From: [REDACTED]
To: [One Earth Solar](#)
Subject: Deadline 3 submissions.
Date: 09 September 2025 15:15:30
Attachments: [Critical Assessment of the One Earth Proposal.docx](#)
[Submission on Sequential and Exception Test Failures in One Earth Solar Farm NSIP.docx](#)
[WFD Compliance.docx](#)
[Flood risk including cumulative effects and resource deficit..docx](#)
[Cost of floodingExpanded Cost Analysis of the One Earth Solar Farm.docx](#)
[Public safety..docx](#)

Interested Party Reference number: FA3AE8AE5

Report on Sequential and Exception Test Failures in One Earth Solar Farm NSIP

This report has been prepared for submission to the Examining Authority under the Planning Act 2008 in relation to the One Earth Solar Farm Nationally Significant Infrastructure Project (NSIP). It offers a critical examination of the Applicant's application of the Sequential and Exception Tests as required by the National Planning Policy Framework (NPPF), the Overarching National Policy Statement for Energy (EN-1), and related guidance. The report integrates a technical review of the Flood Risk Assessment (FRA) as presented in the Environmental Statement (ES) and supporting technical studies. In dra

Figure 17: Siting of substations

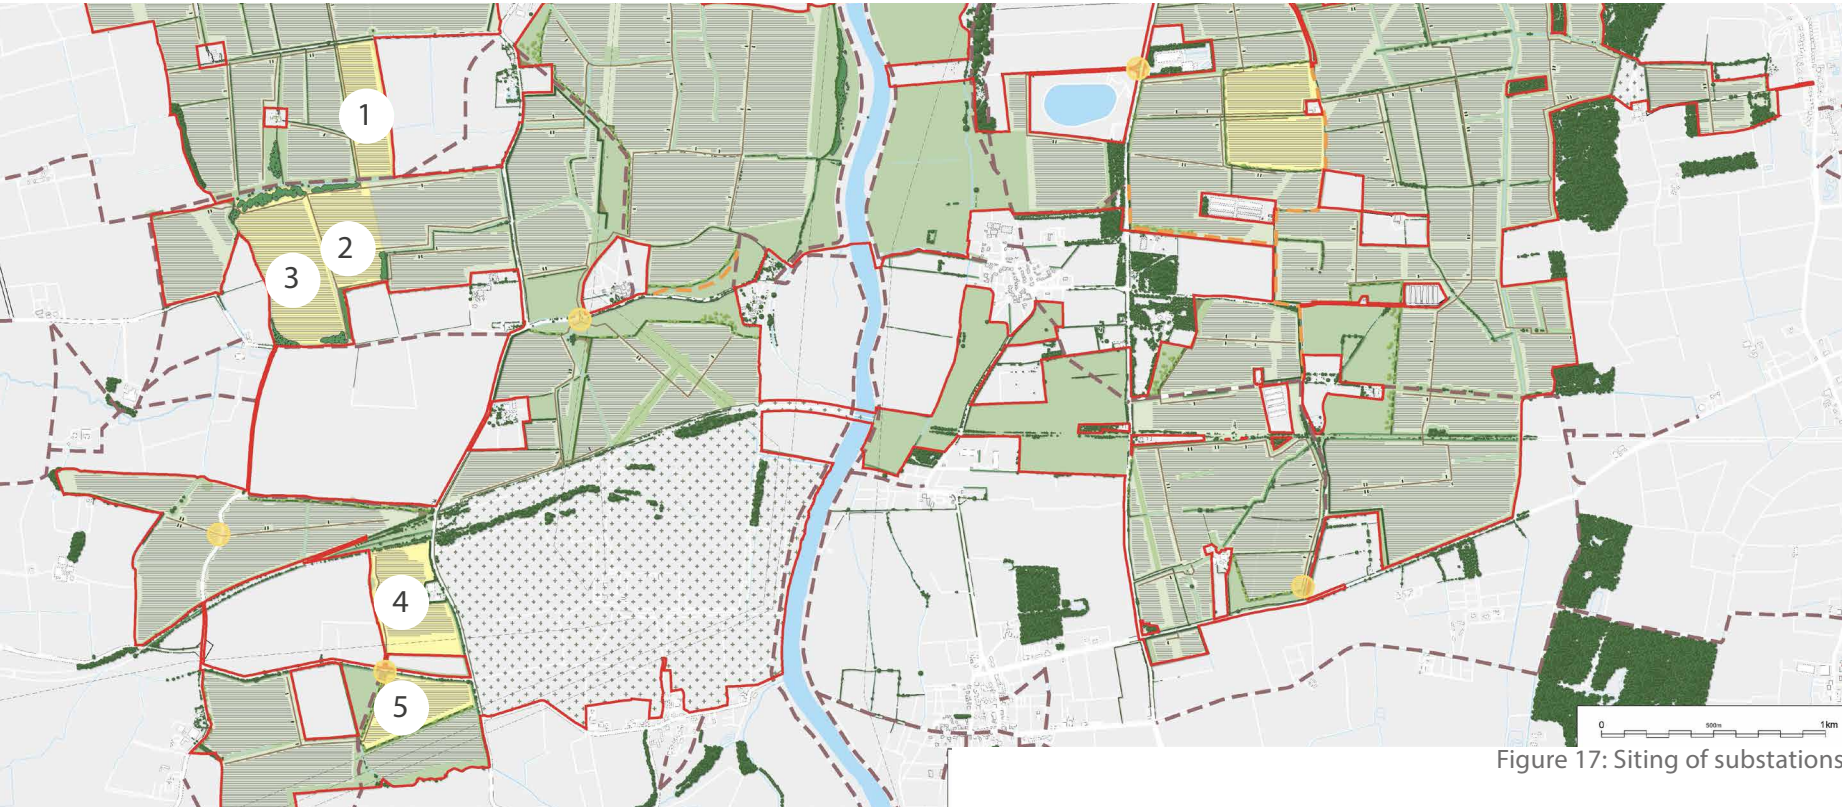
While some panel raising and equipment stowing are described, there is a lack of clear, evidence-based partitioning to keep the substation, battery storage, and other vulnerable components wholly out of the highest risk situation—contrary to the design requirement at site level. Most notably, the substations' proposed location, as detailed in the FRA, includes significant areas of Flood Zone 3, with no convincing demonstration that these installations cannot be relocated within the site's order limits to less hazardous ground.
